To: Ben Walter/ Guy Lebrecque
From: Mike Nugent
Date: 2/17/2005
Re: YMCA / SRO (036 G020)

I have commence the review of the plans, into but not completely through Chapter 7 of the 2003 IBC and have the following questions:

Issuing Title:
TYPICAL WALL SECTIONS

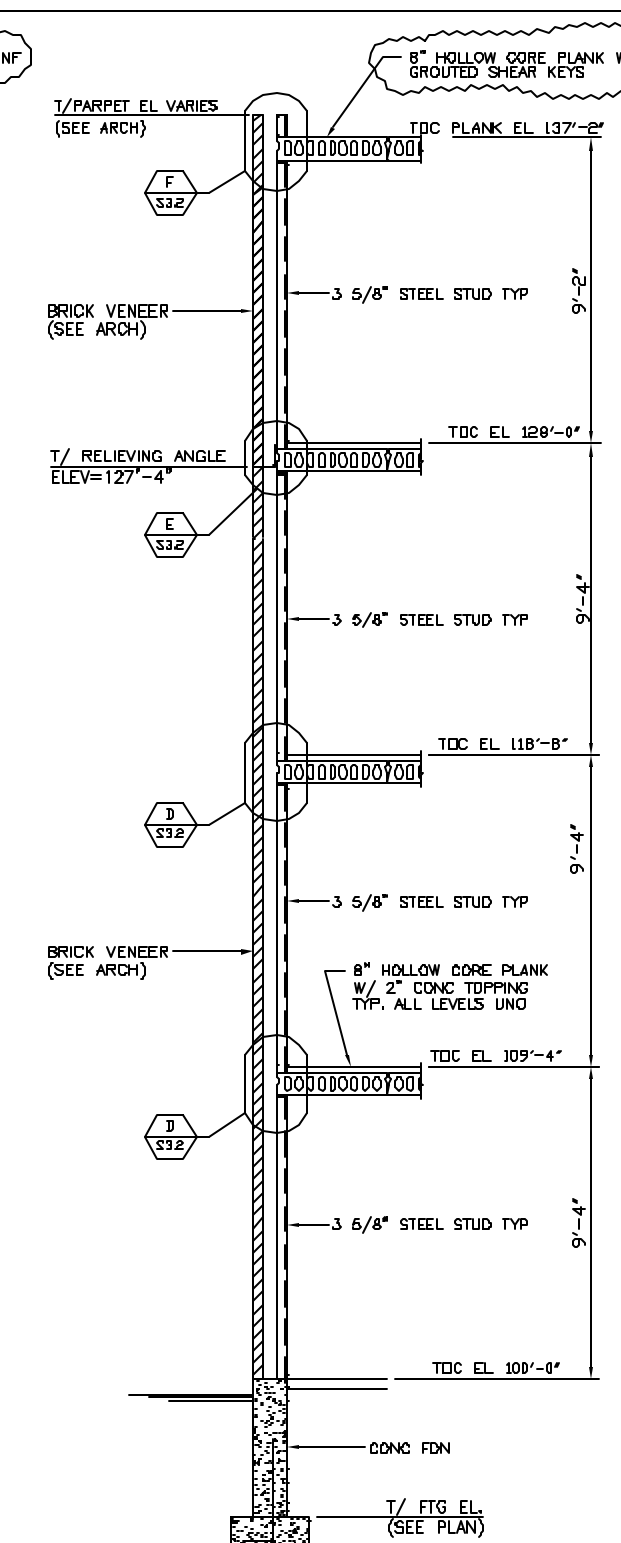
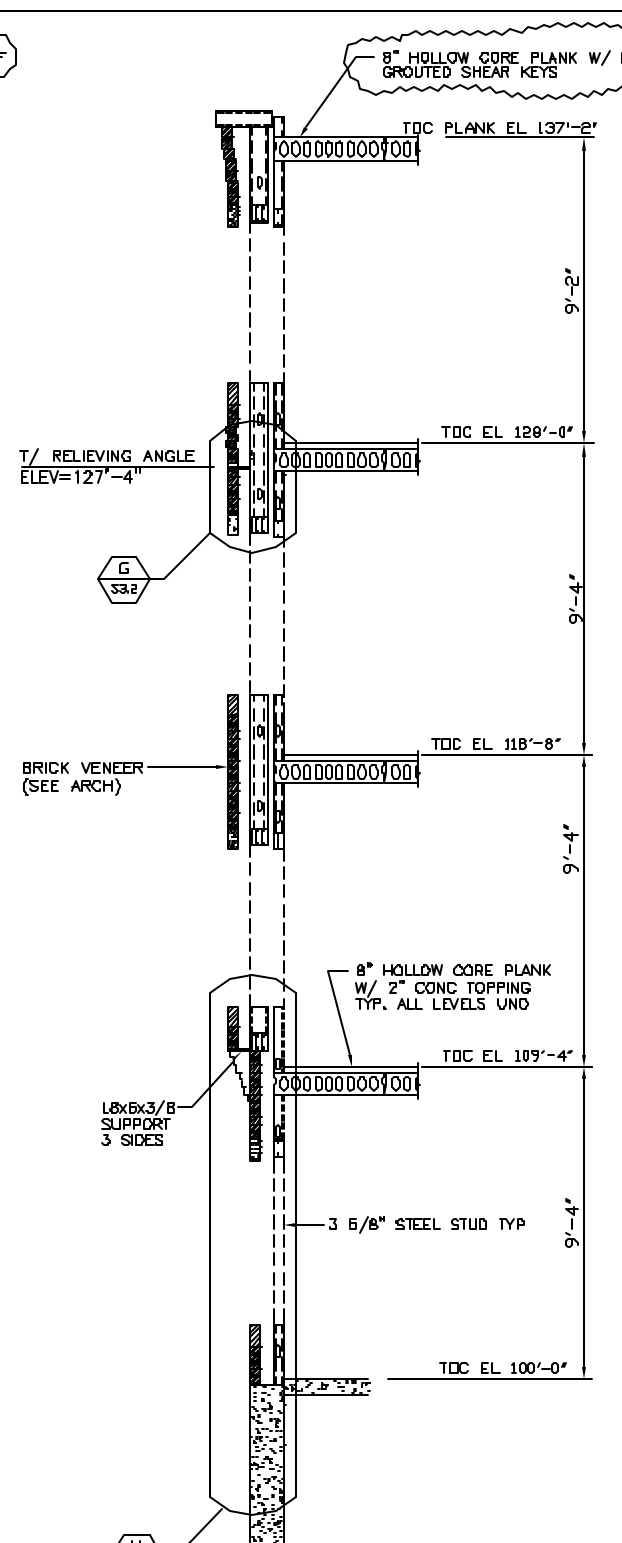
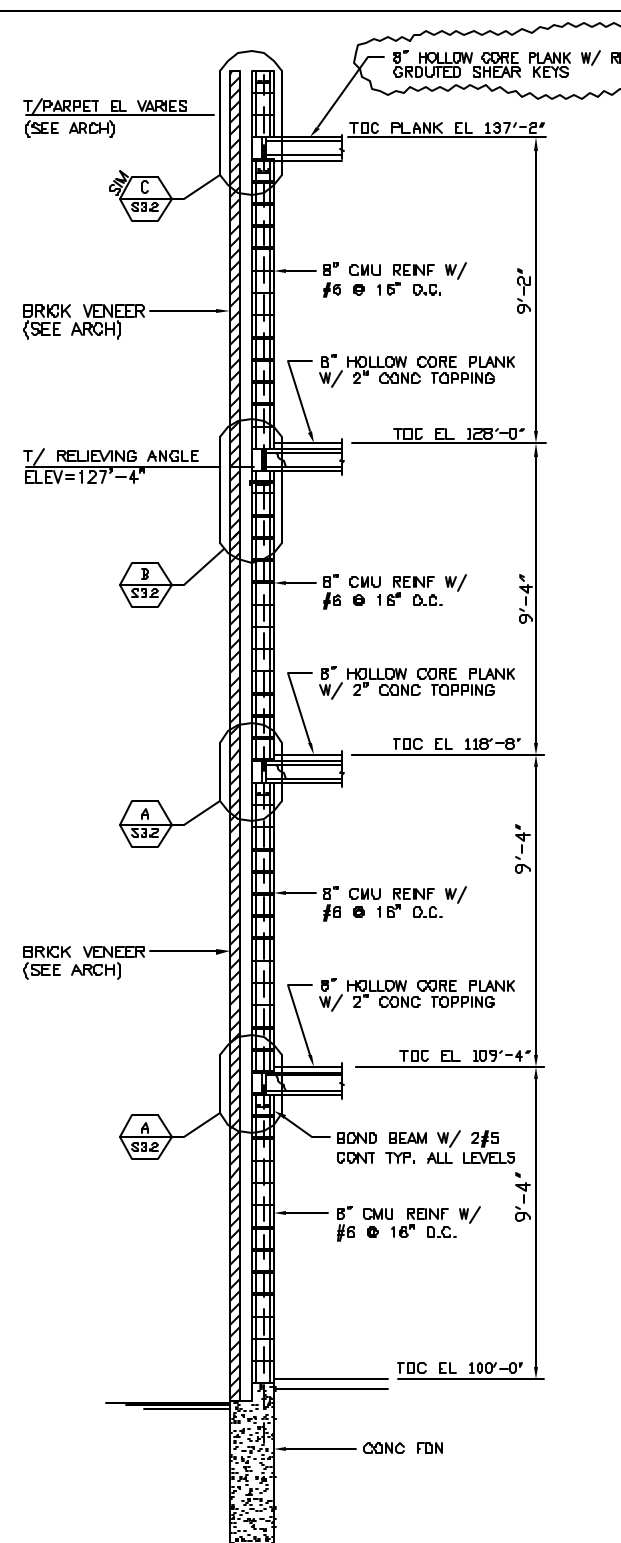
- 1) Is the exterior wall going to be a masonry veneer, “brick like” look or will it be “real” brick?
- 2) I don’t have the Fire rating of the exterior walls , Table 601 requires that exterior bearing walls have a 2 Hr. Rating.
- 3) I’m looking at 25% unprotected openings in the North building face. Our original discussions indicated that this building will be protected with an NFPA 13R system, which does not allow us to give “protected” status to the exterior openings. This being the case, the Code allows no openings on that side. We had talked about a waiver, but have no such request or proposal for alternative protections. Similarly for the South face, where it’s close to the “Y”.
- 4) What is the Fire resistance rating and STC for the Floor Ceiling assemblies?
- 5) What is the STC for the walls separating the Dwellings from each other as well as the common areas?
